**Town & Country Planning Act 1990 (as amended) s211 Notice
Application for Prior Notification of Work to Tree(s) in a Conservation Area**

Development Various works to various trees within Church Road, Yapton Conservation Area

Location Berri Court Main Road Yapton West Sussex

## BERRICOURT TREE PLAN

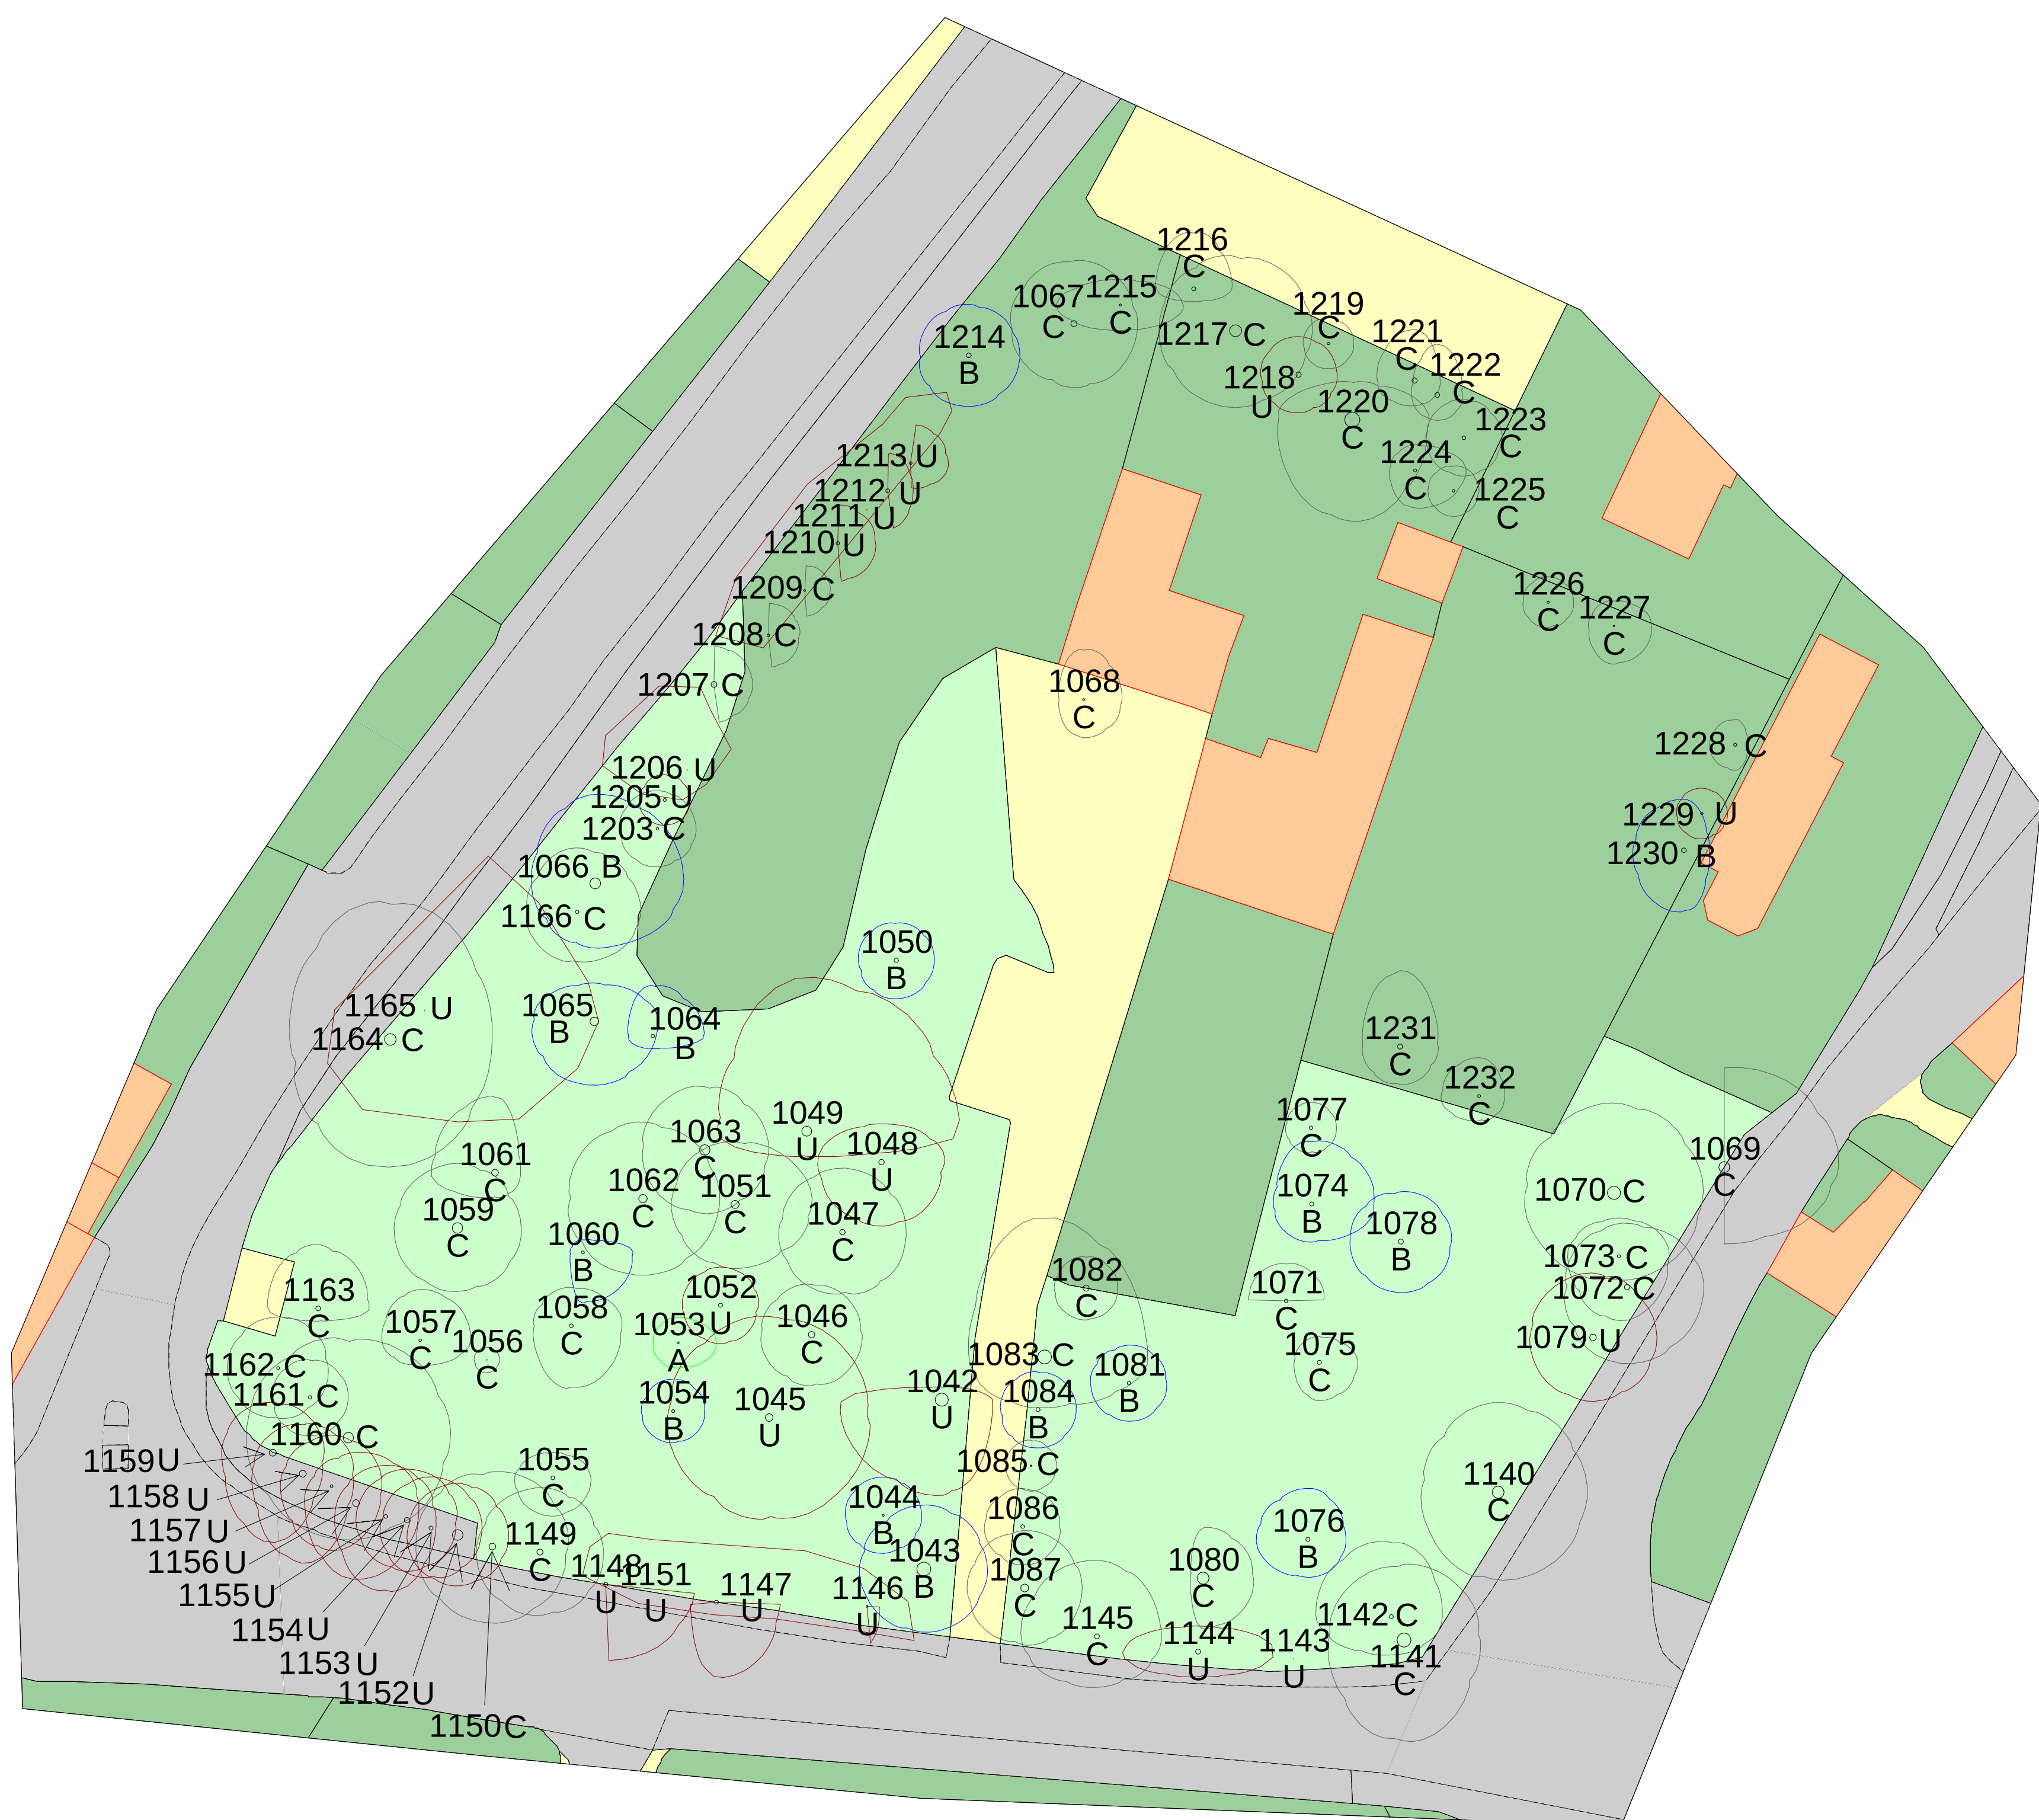
Please give a measurement, in metres, detailing the crown lift you are wishing to perform on Tree 1043.

Please give clarification as to what species Tree 1045 is.

Please clarify the works you wish to perform to Tree 1061. You cannot have 'and/or', the works must be specific.

Please give clarification as to what species Tree 1068 is.

Please list how many trees there are in Group 1073.

Please clarify the works you wish to perform to Tree 1079. You cannot have 'and/or', the works must be specific.

Please detail the number and species of the trees in Group 1143, 1151, 1165, 1206 & 1211.

Please clarify the works you wish to perform to Tree 1207. You cannot have 'and/or', the works must be specific.

Please clarify the works you wish to perform to Tree 1212. You cannot have 'and/or', the works must be specific.

Please clarify the works you wish to perform to Tree 1217. You cannot have 'and/or', the works must be specific.
